North Sydney Public School SSD-11869481

182 Pacific Highway, North Sydney

Objection by Edward Precinct

TREE REMOVAL SCHEDULE

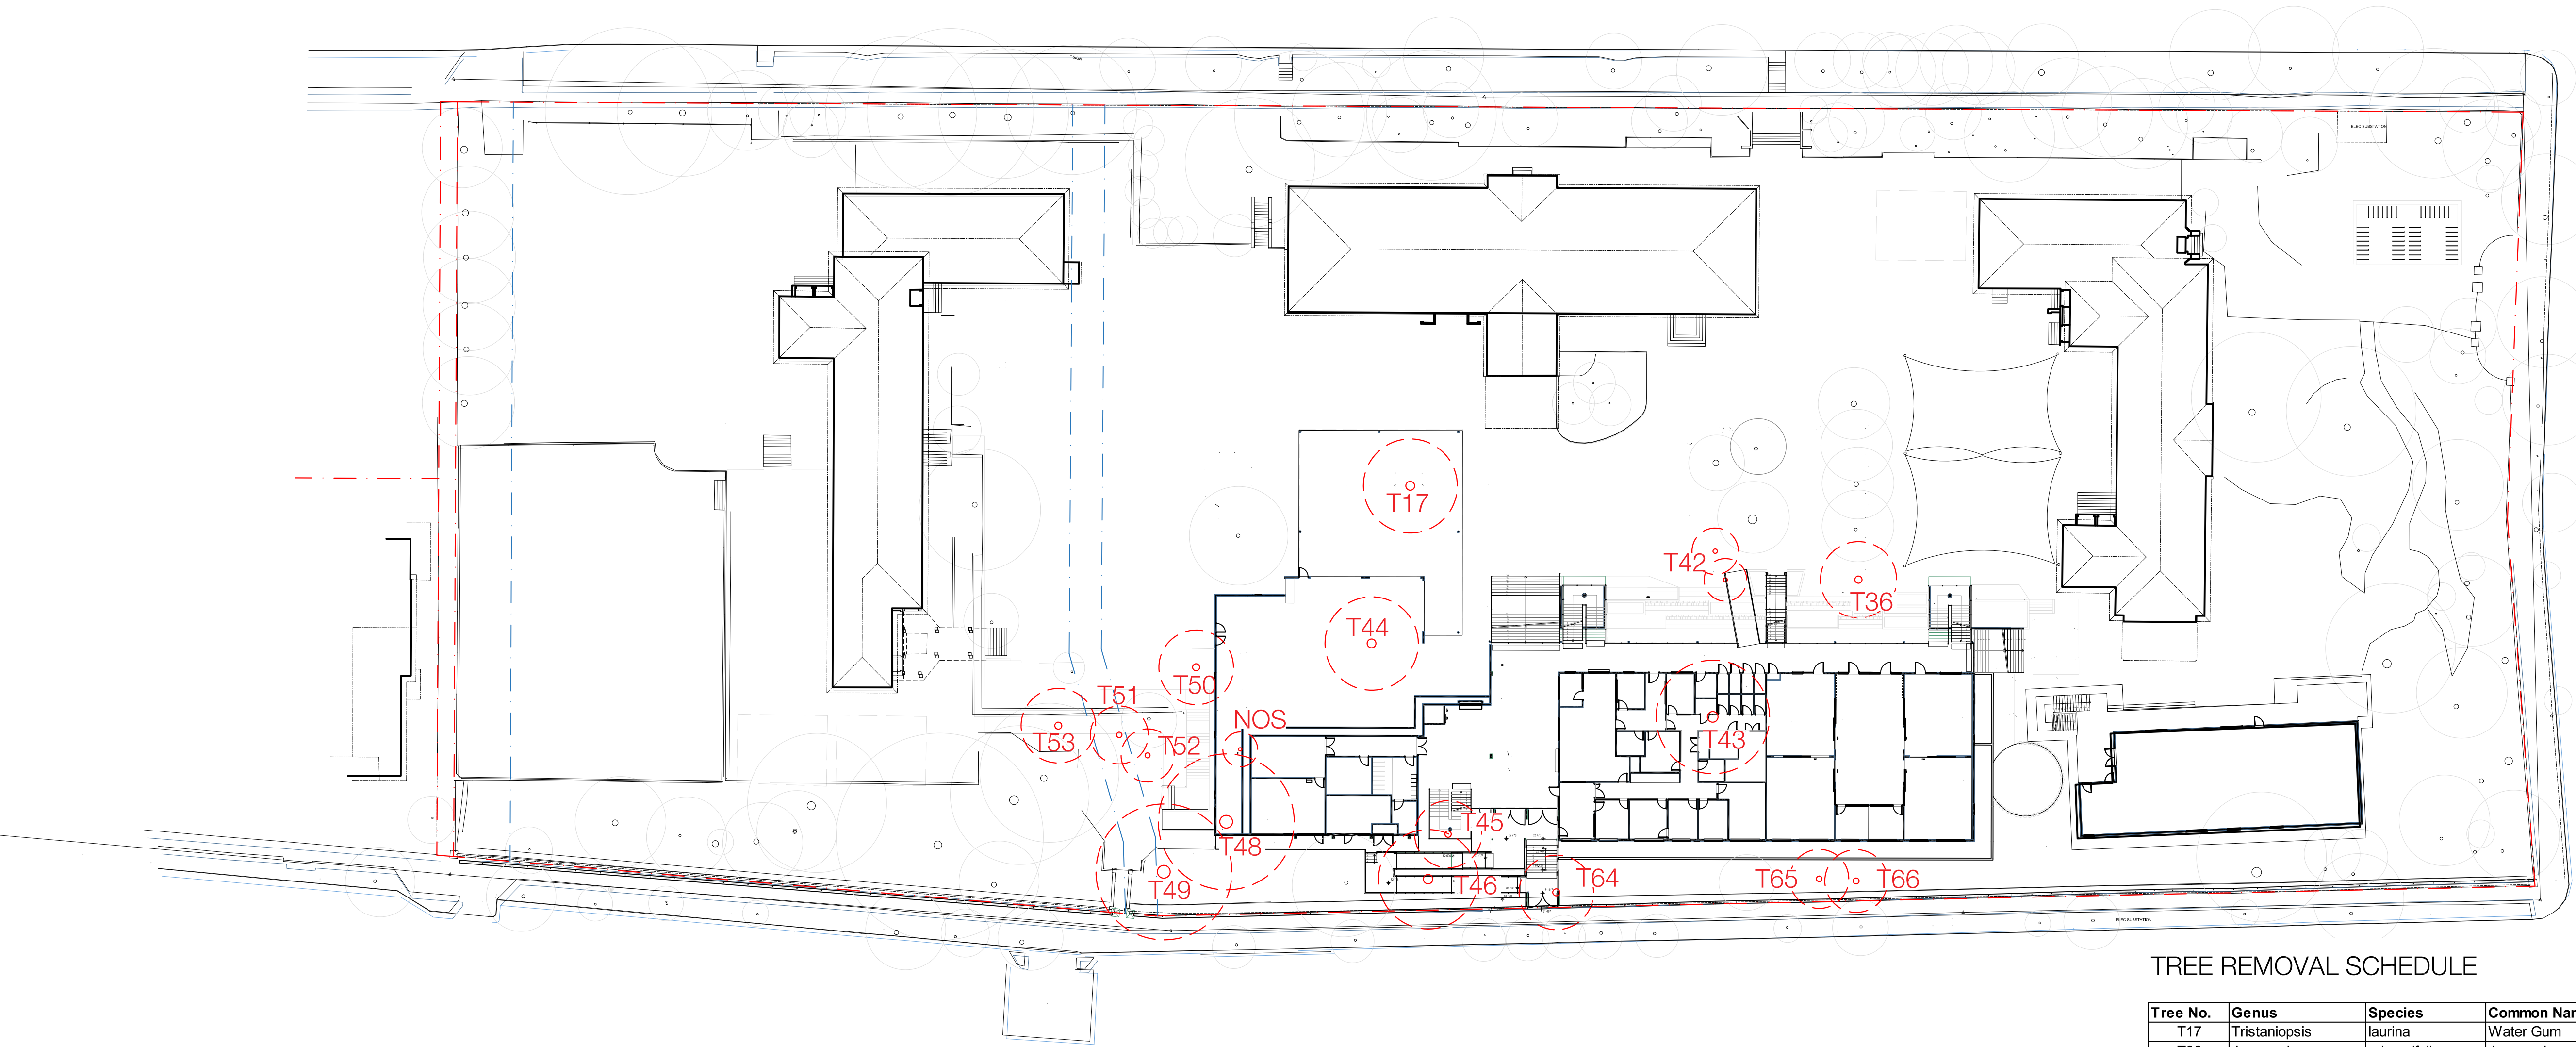
The proposed design removes too many mature trees. These trees have been planted over three decades by the school community to green both the school and North Sydney. Their removal produces a poor environment for the school children, their neighbours and the community of North Sydney. This green buffer provides an important protection for the school from the impact of traffic on Bay Road and the Pacific Highway.

1 ELEVATION
BUILDING J - SOUTH ELEVATION
SCALE: 1:100

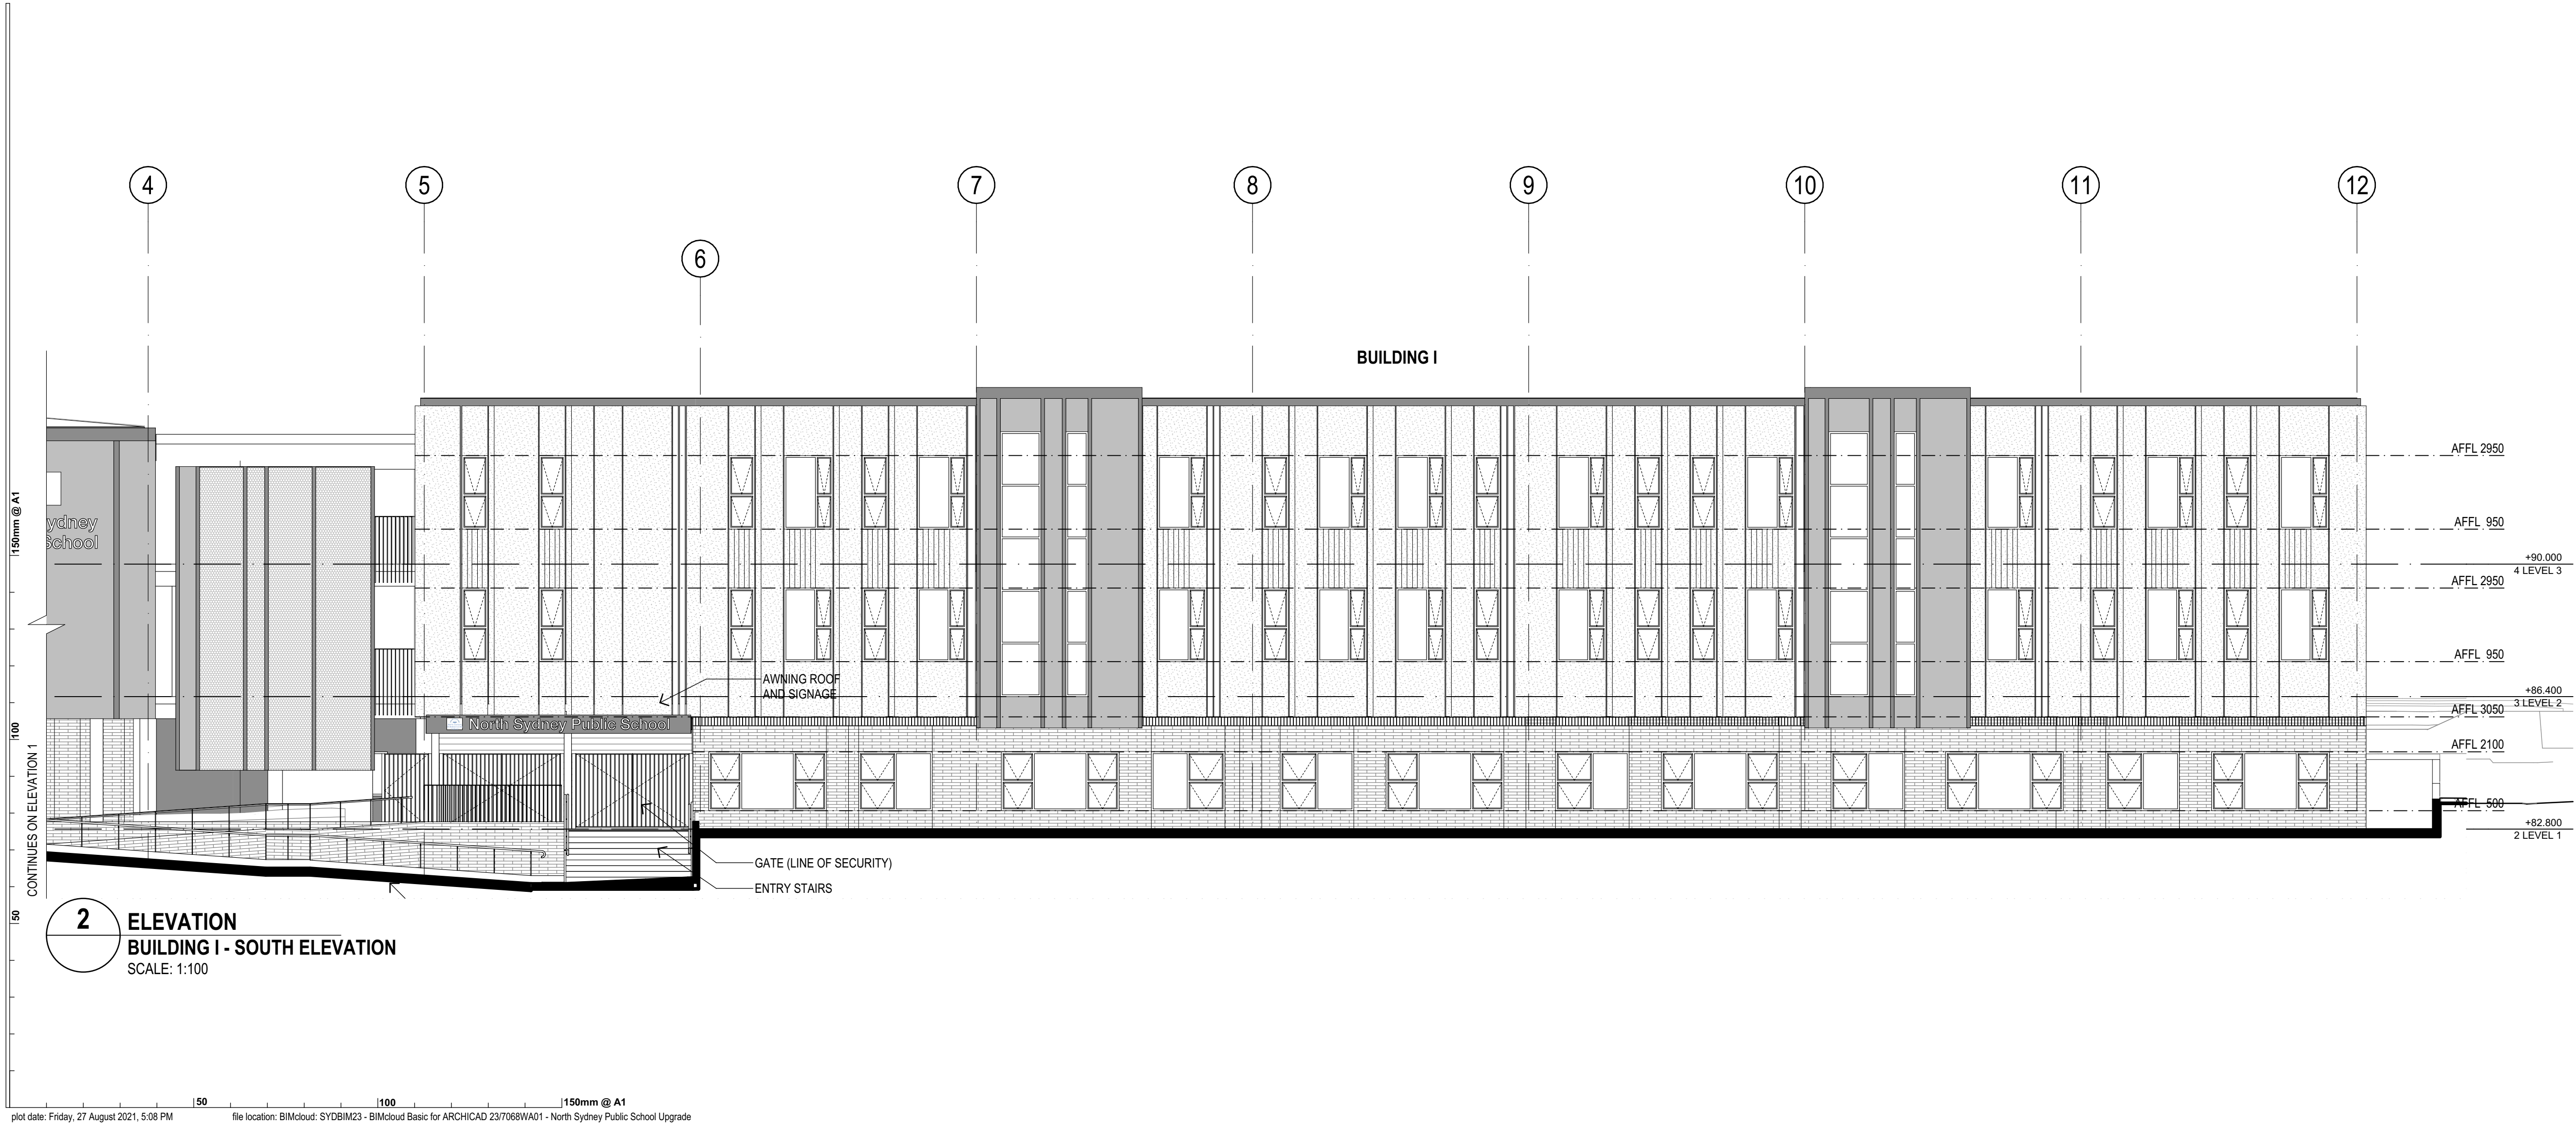
The brick base and lightly coloured two-storey facade is out of character with the existing heritage buildings which are all face brick. The chosen GRC facade does not have the depth that the existing brick facades have and appears insubstantial by comparison.

Finally we believe the illustrations of the proposed buildings are not adequate. For example the public realm along Bay Road is not clearly shown as the footpath is missing (on page 11 of the architectural drawings). Also the ground floor windows are not shown, falsely giving the appearance of a solid base.
